StreetWise response to TfNSW comments in regard to proposed Recycling & Resource Recovery Facility, Torrens Road, Gunnedah

I refer to the recent comments from Transport for New South Wales, in regard to the previous Traffic Impact Assessment (TIA) prepared by StreetWise for the proposed Recycling & Resource Recovery Facility at Torrens Road, Gunnedah.

Transport for NSW Response

DRAWING TITLE				
SWEEP PATH ANALYSIS PLAN - AV				
PROJECT NO.	PLANSET NO.	RELEASE NO.	DRAWING NO.	REVISION
P1907434	PS01	R16	PS01-GZ00	L

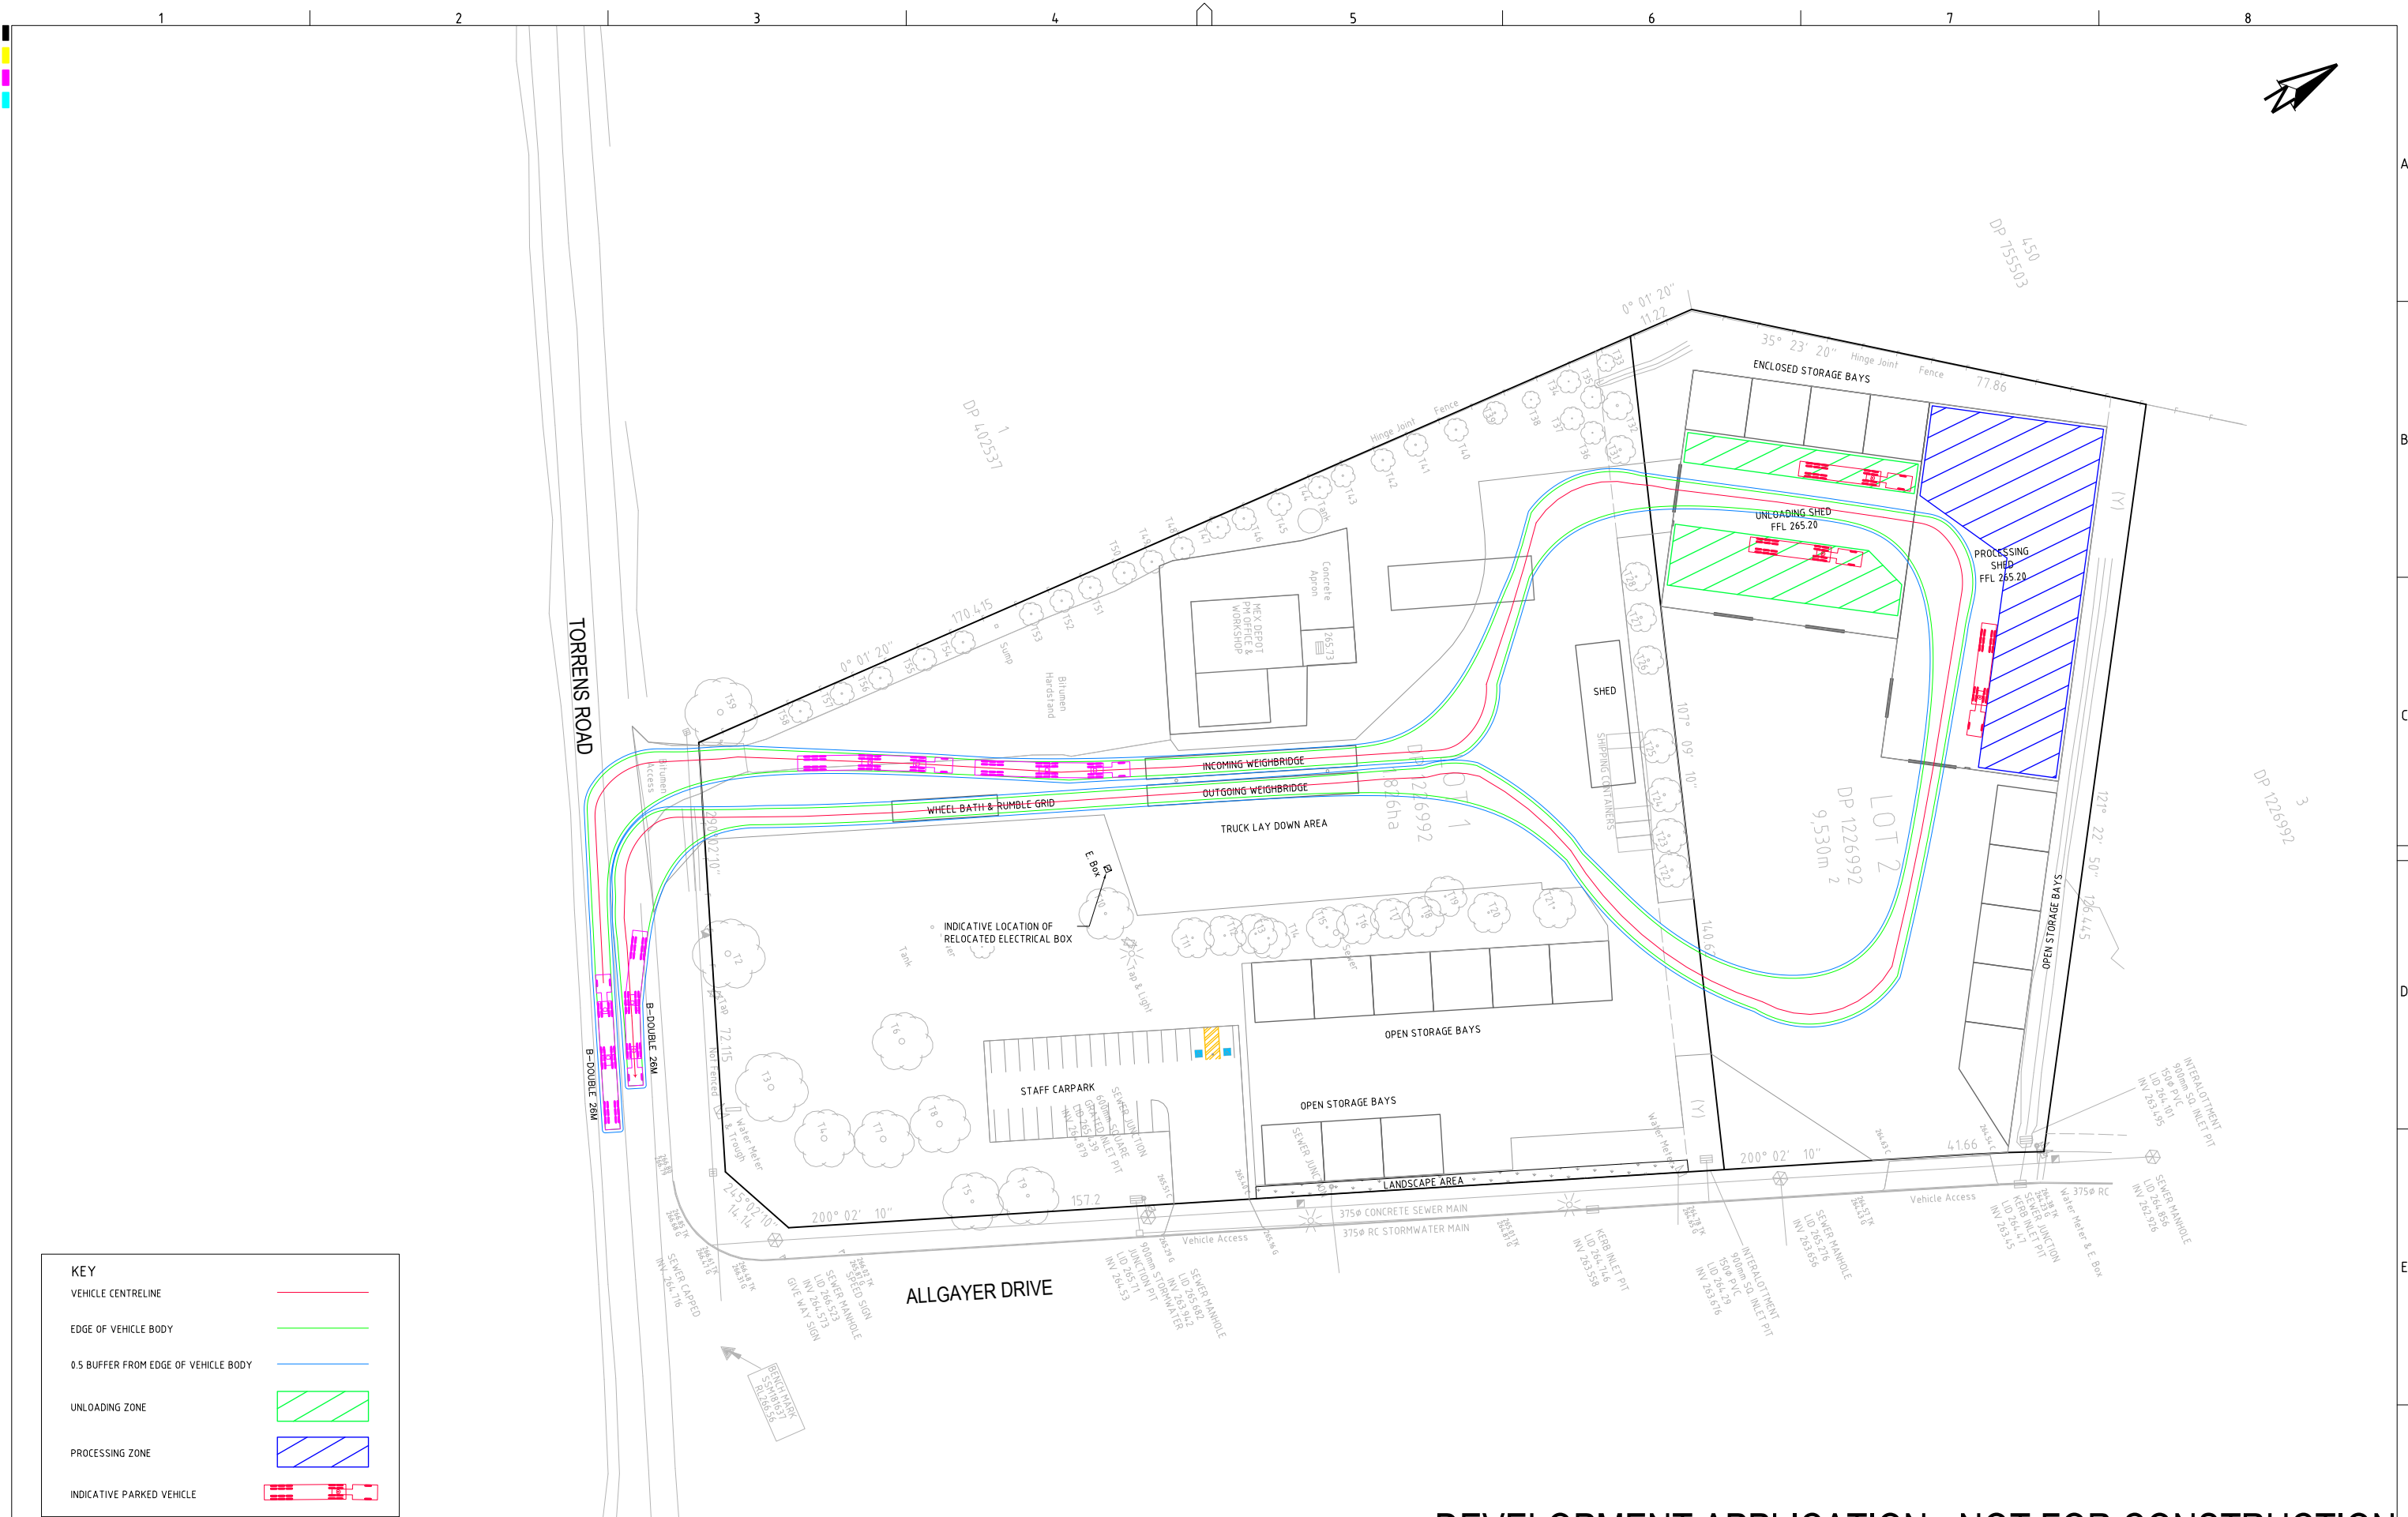
6. 'MEX Depot access details were not quantified in the TIA and therefore it is no possible to check if they meet AS2890 requirements. Swept paths appear to indicate that a B-Double cannot exit onto the correct side of the road. This should be reviewed.'

The design plans for the future Recycling & Resource Recovery Facility have been updated. The amended plans show details of the upgraded driveway / access from Torrens Road into the site, as well as turnpaths for B-double vehicles. As can be seen from the image below, and the swept-paths provided by Martens & Associates, the widened driveway provides adequate width for all heavy vehicles to turn safely in and out of the site, without the need to cross the Torrens Road centreline.
